Tipperary County Council
c/o Gillian Flynn
Civic Offices
Clonmel
Co. Tipperary

Date: 09 July 2024

Re: Proposed road development at The Quay, Quay Street, Suir Island and Raheen Road
The Quay, Quay Street, Suir Island and Raheen Road, Clonmel County Tipperary

Please be advised that the Board, in accordance with section 51(4) of the Roads Act 1993, as amended, hereby requires you to furnish the following additional information in relation to the likely effects on the environment of the proposed road development:

TIPPERARY COUNTY COUNCIL
SUIR ISLAND INFRASTRUCTURE LINKS
PREFERRED OPTION 01
OVERALL PLAN

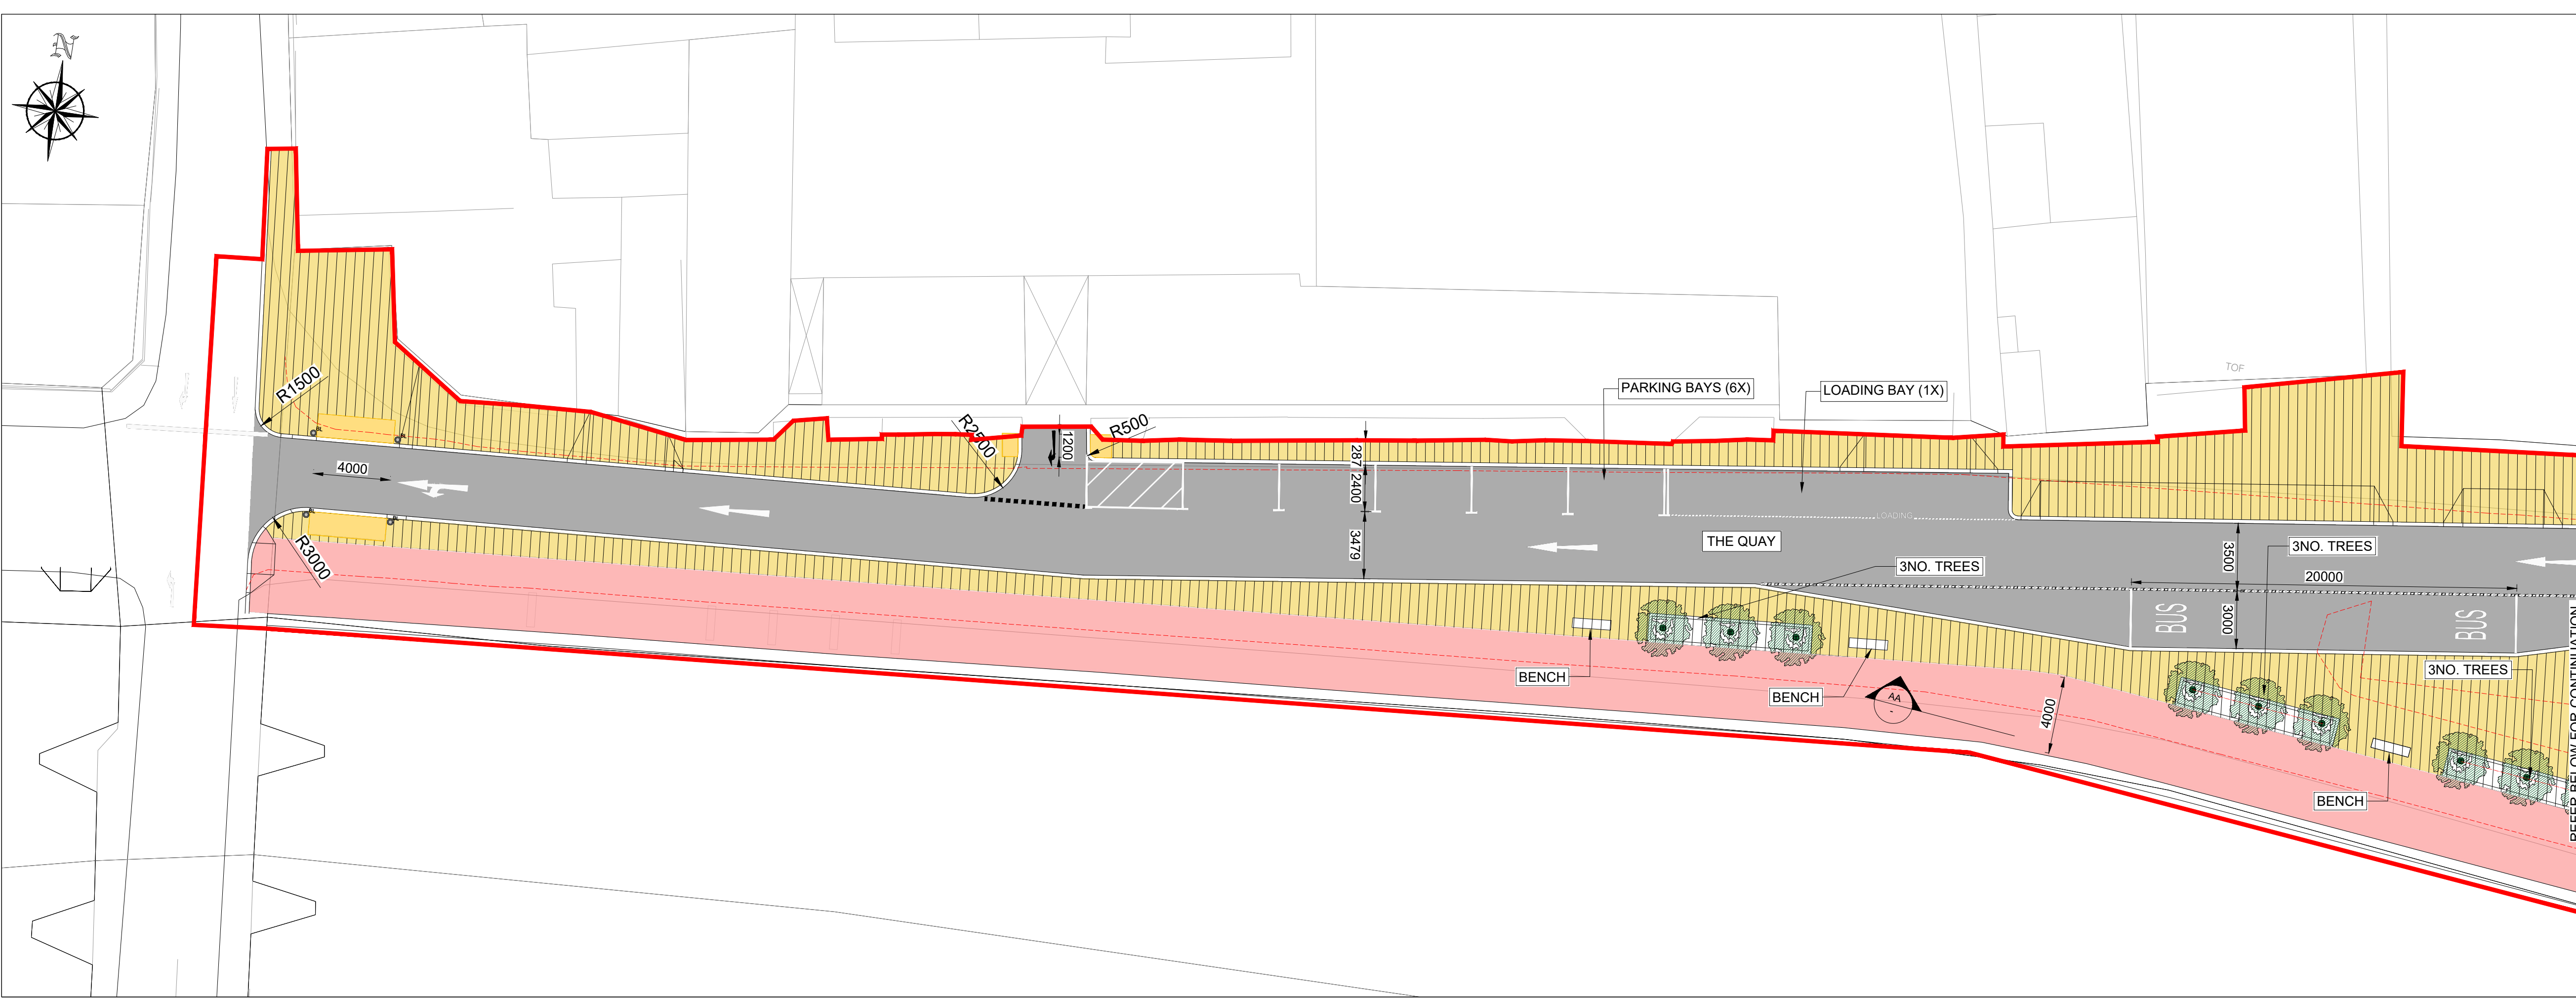
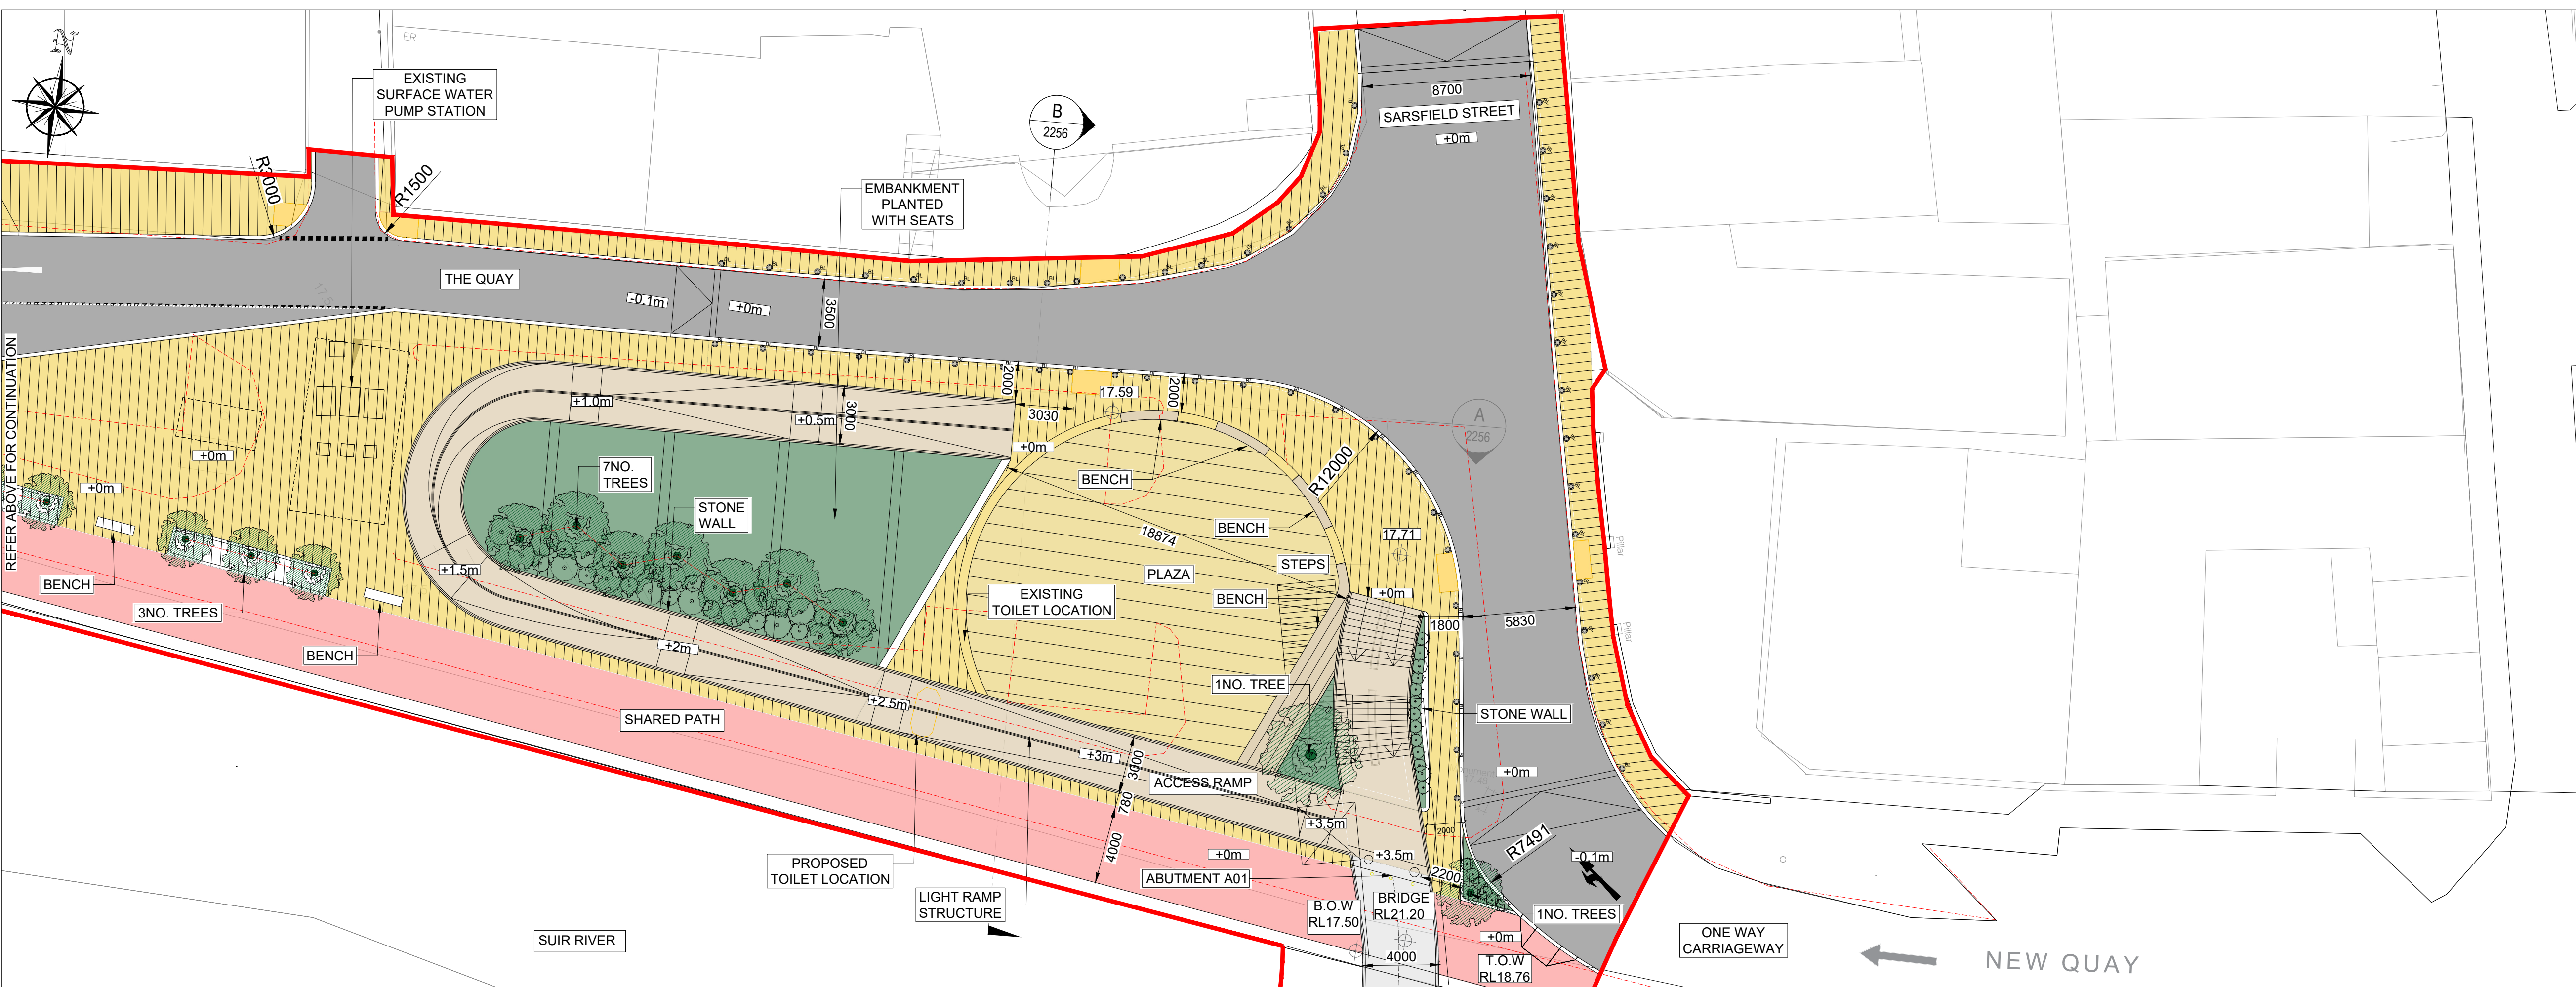
f) The site layout plans include for paths to the eastern area within the site on Suir Island and to the east of the site on Suir Island. Clarification on any proposed paths at these locations should be outlined. The applicant is advised that should consent be sought for same, these would be subject to the provisions of the Planning and Development Act 2000, as amended.

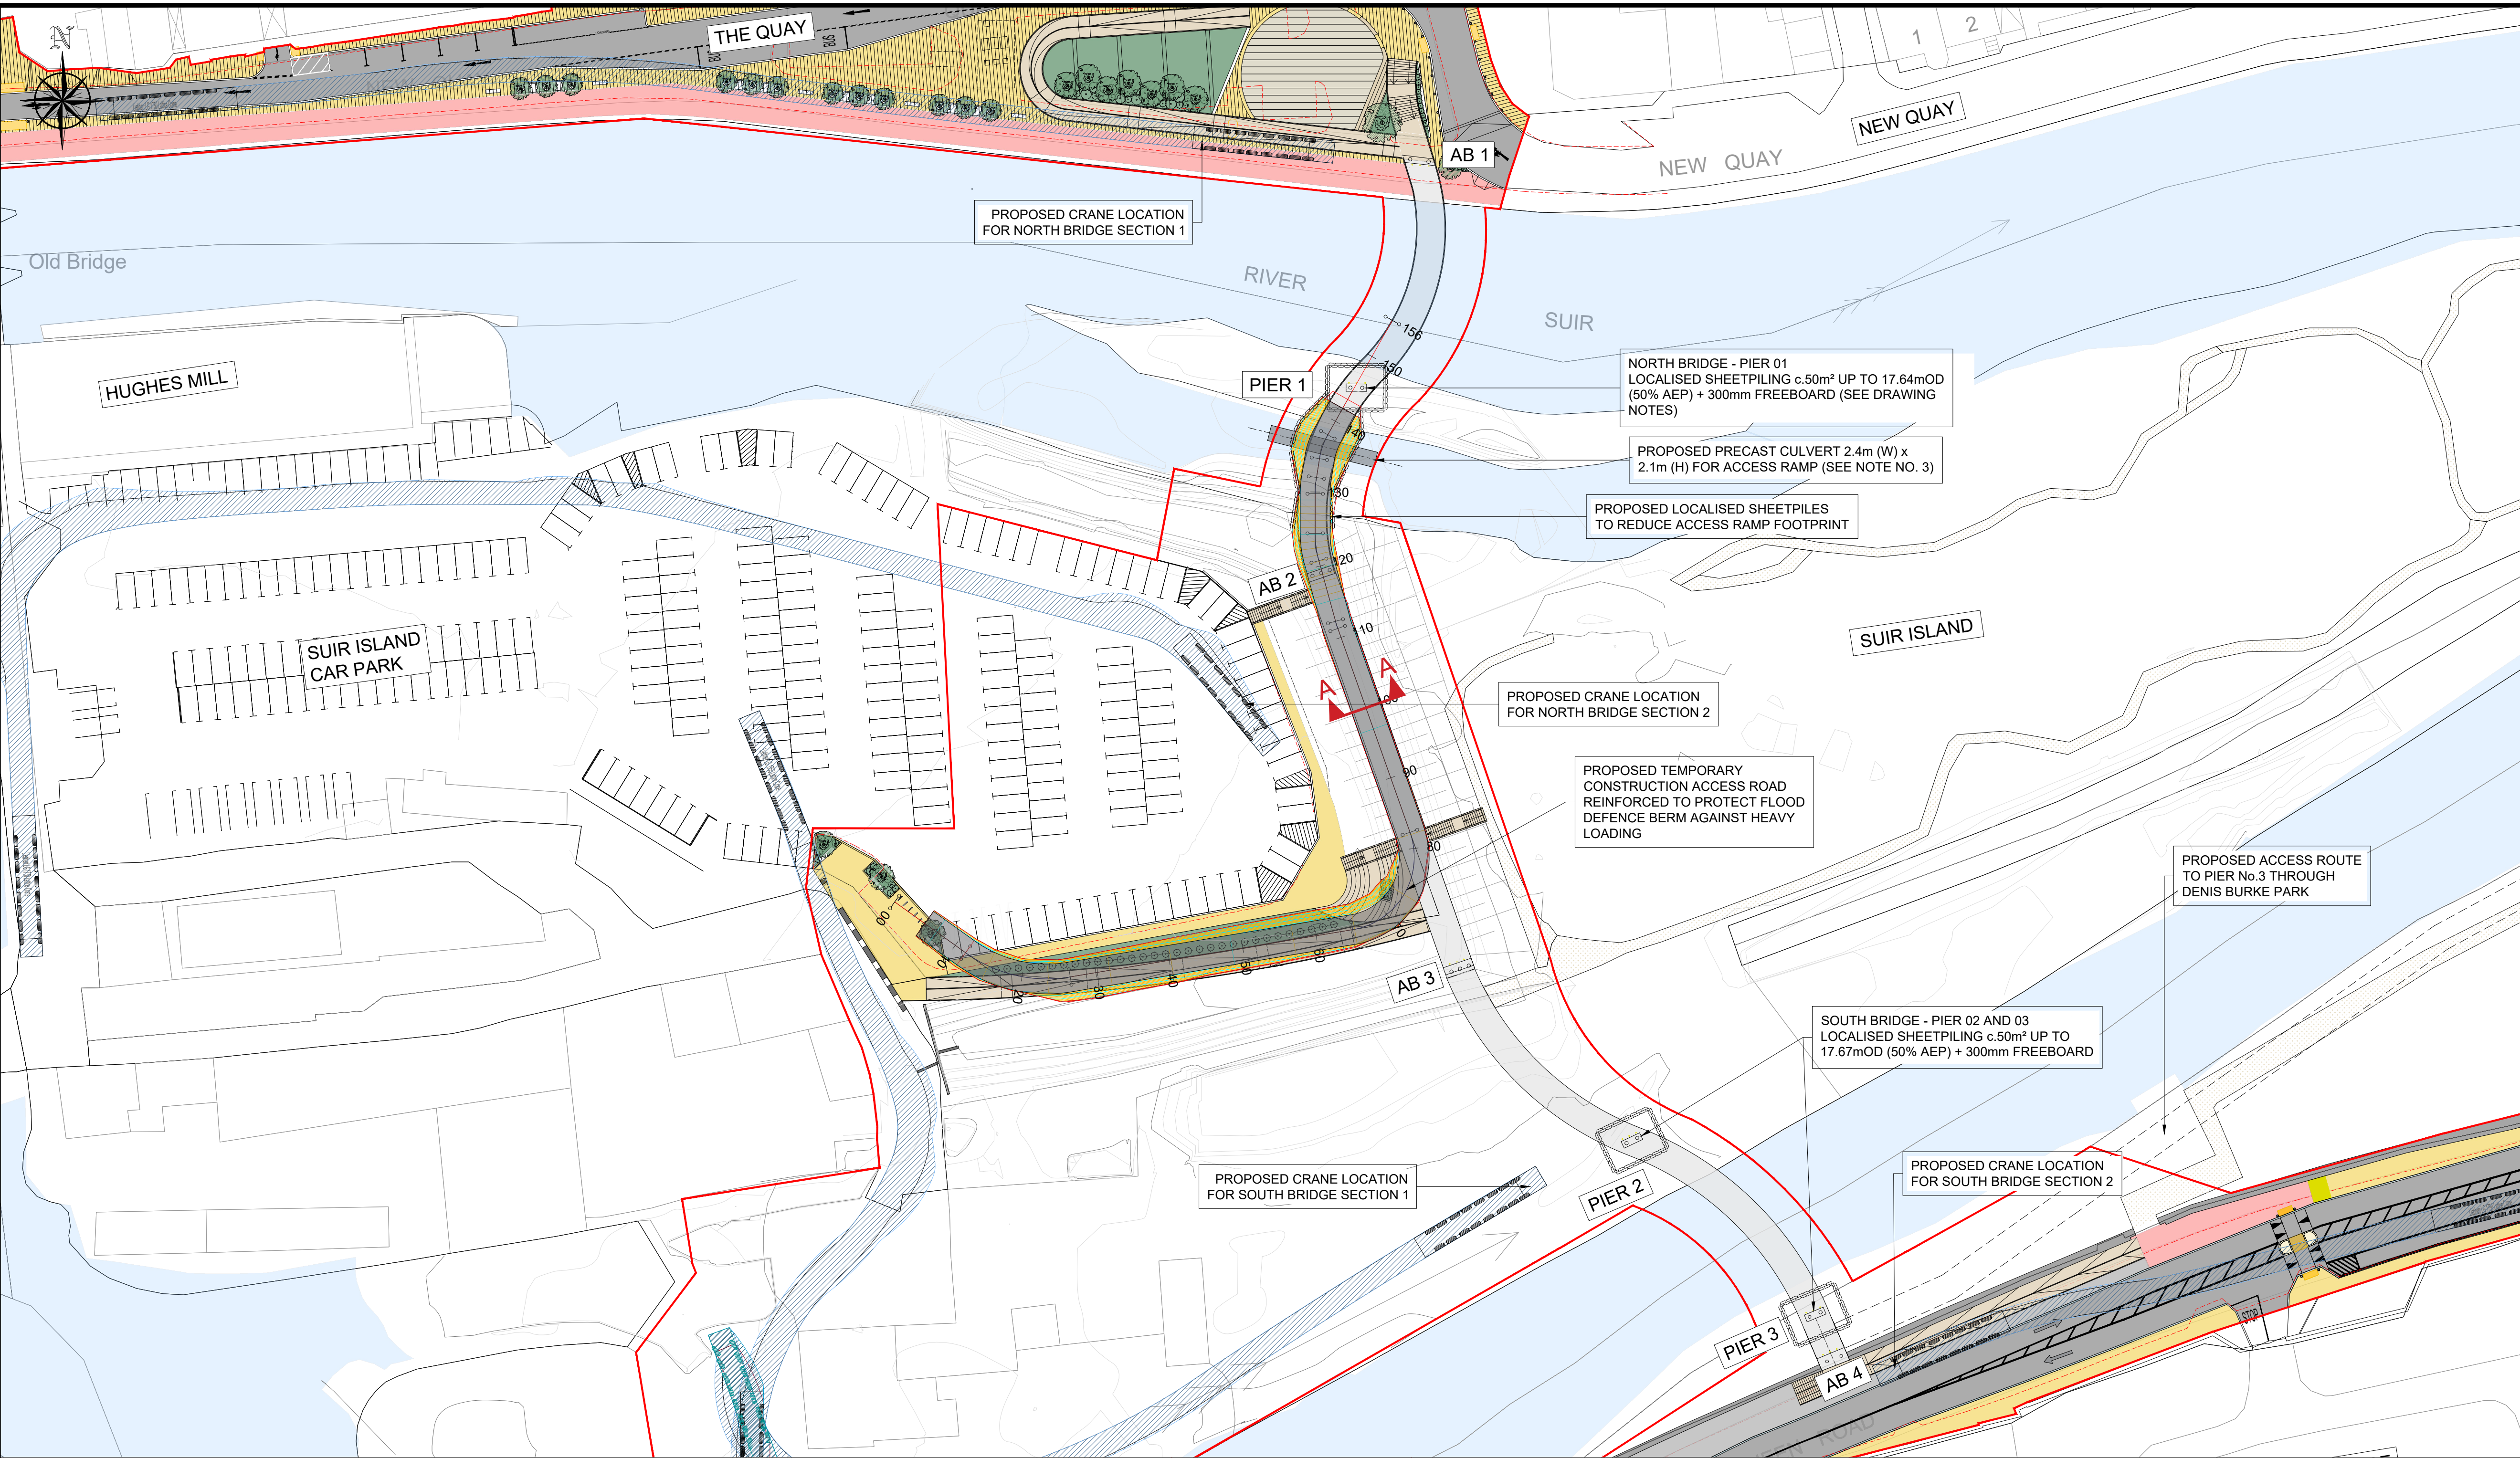
(i) The EIAR outlines there will be no in-stream works and no direct loss or disturbance to instream habitats. However, the proposed development includes for the construction of temporary access ramp and installation of a pre-cast box culvert at the site area of a back-water flood channel to the south of Pier 1 which conveys water during flood events, with sheet piling proposed at this location. From application drawings submitted, the ground level of the culvert corresponds to the approx. base flow as indicated on plans (drawing no.2460) and is below the 1%, 10% and 50% AEP. It is also noted that proposed piers and abutment works located within the flood barriers/defences are below the level of AEPs, which is particularly the case for the proposed southern bridge (drawing no.2260). While it is noted that works will be timed to avoid flooding and will be temporary in nature, given the levels outlined and potential for flooding, consideration should be given to the potential impacts arising from instream works, and from instream works arising in periods of increased base flow and flooding. In the event of

c) The NIS outlines the project will not involve any instream works that could result in the loss of instream habitats. However, the proposed development includes for the construction of temporary access ramp and installation of a pre-cast box culvert at the site area of a back-water flood channel to the south of Pier 1 which conveys water during flood events, with sheet piling proposed at this location. From application drawings submitted, the ground level of the culvert corresponds to the approx. base flow as indicated on plans (drawing no.2460) and is below the 1%, 10% and 50% AEP. It is also noted that proposed piers and abutment works located within the flood barriers/defences are below the level of AEPs, which is particularly the case for the proposed southern bridge (drawing no.2260). While it is noted that works will be timed to avoid flooding and will be temporary in nature, given the levels outlined and potential for flooding, consideration should be given to the potential impacts arising from instream works, and from instream works arising in periods of increased base flow and flooding. In the event of potential impacts being identified, appropriate mitigation measures addressing same are to be outlined, where applicable.
